CITY OF ALBUQUERQUE

January 5, 2012

Re: Chelwood Park Apartments Grading and Drainage Plan
Engineer's Stamp date 12-28-11 (J22/D001)

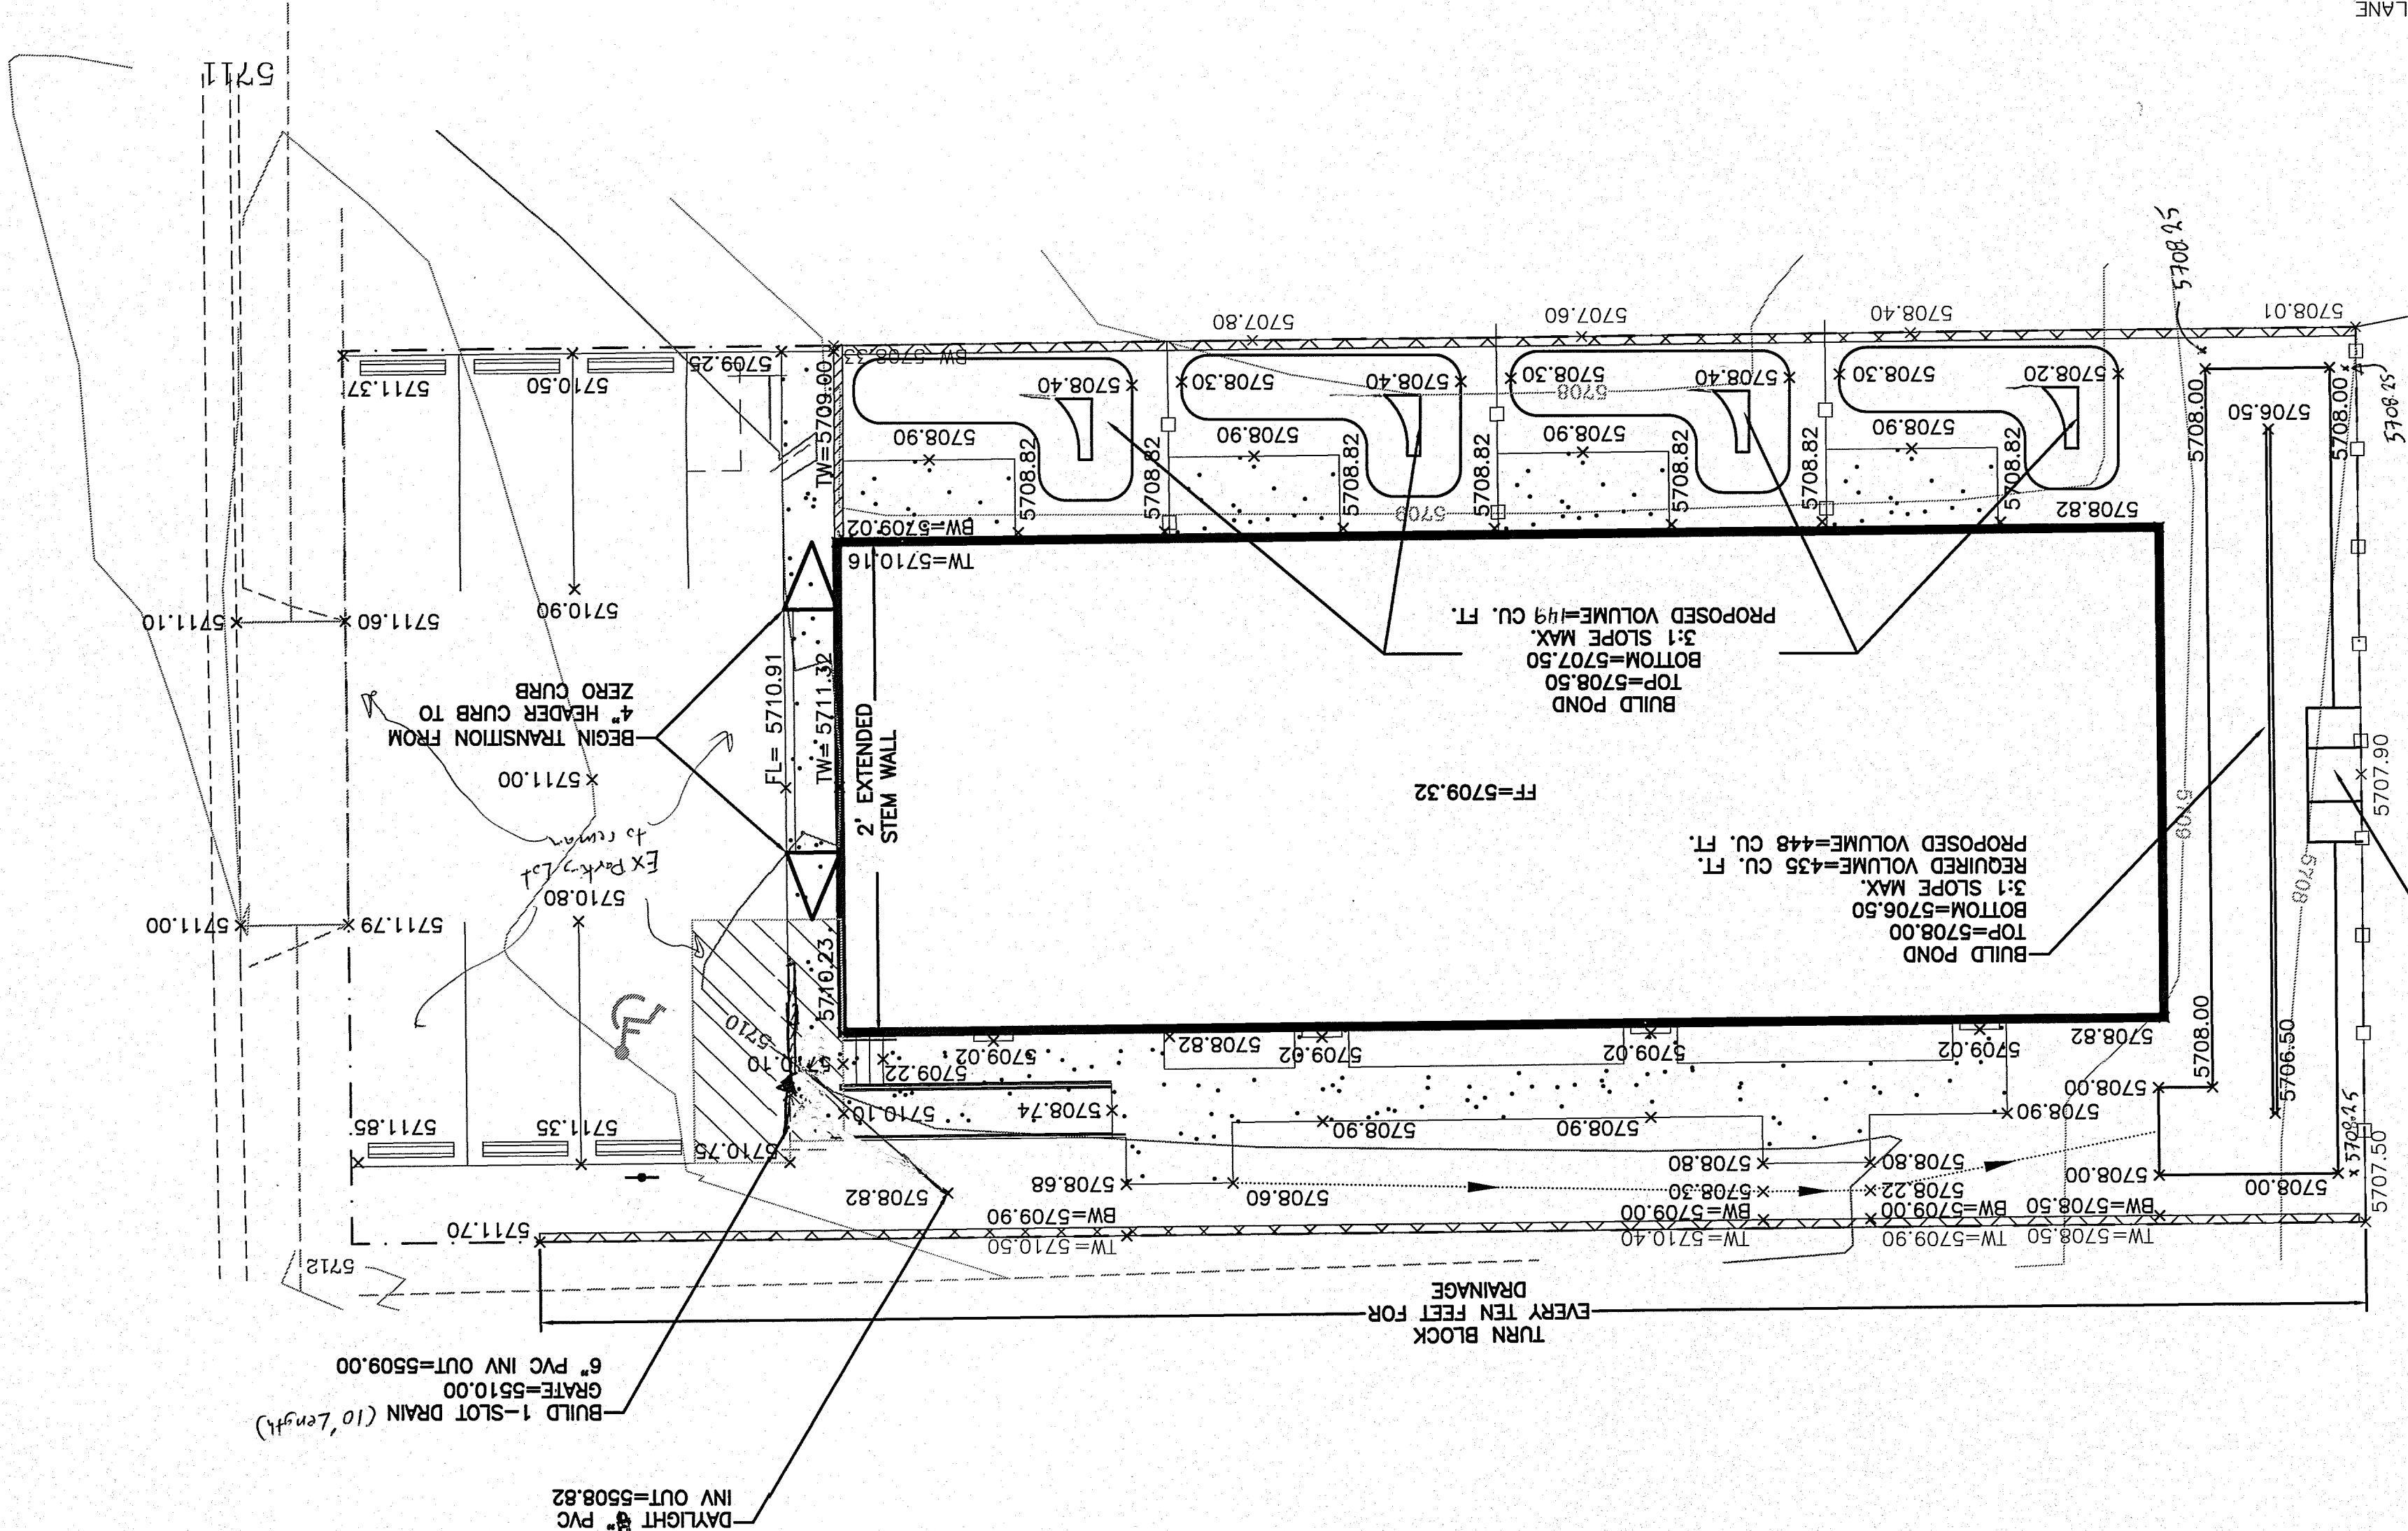
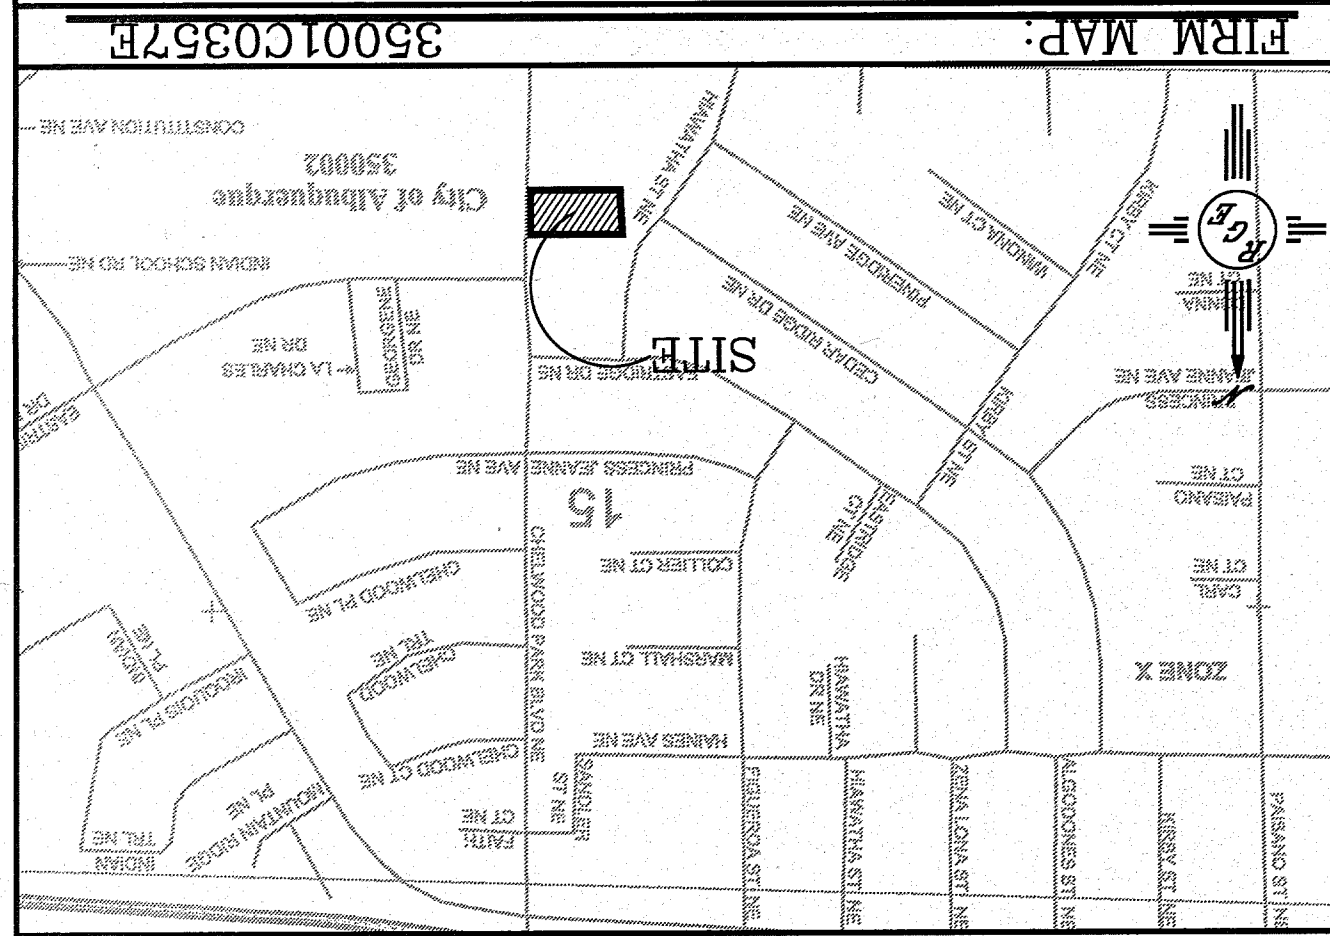
- Hydrology recommends that your rear yard ponds be graded to spill over towards the west into the larger pond once they have exceeded capacity.
- The emergency overflow in the larger western pond should then spill over towards the western property line.
- The proposed screen wall on the northern edge appears to redirect and concentrate existing flows at a point, is it possible to allow these flows to still penetrate the wall in a few locations?
- The drive entrance should include spot elevations along Chelwood Boulevard to ensure an adequate water block is provided.
- Are the spot elevations provided at the southern portion of the parking area intended to match existing grades?
- Provide additional spot elevations in the parking lot to ensure that the basins drain as intended.
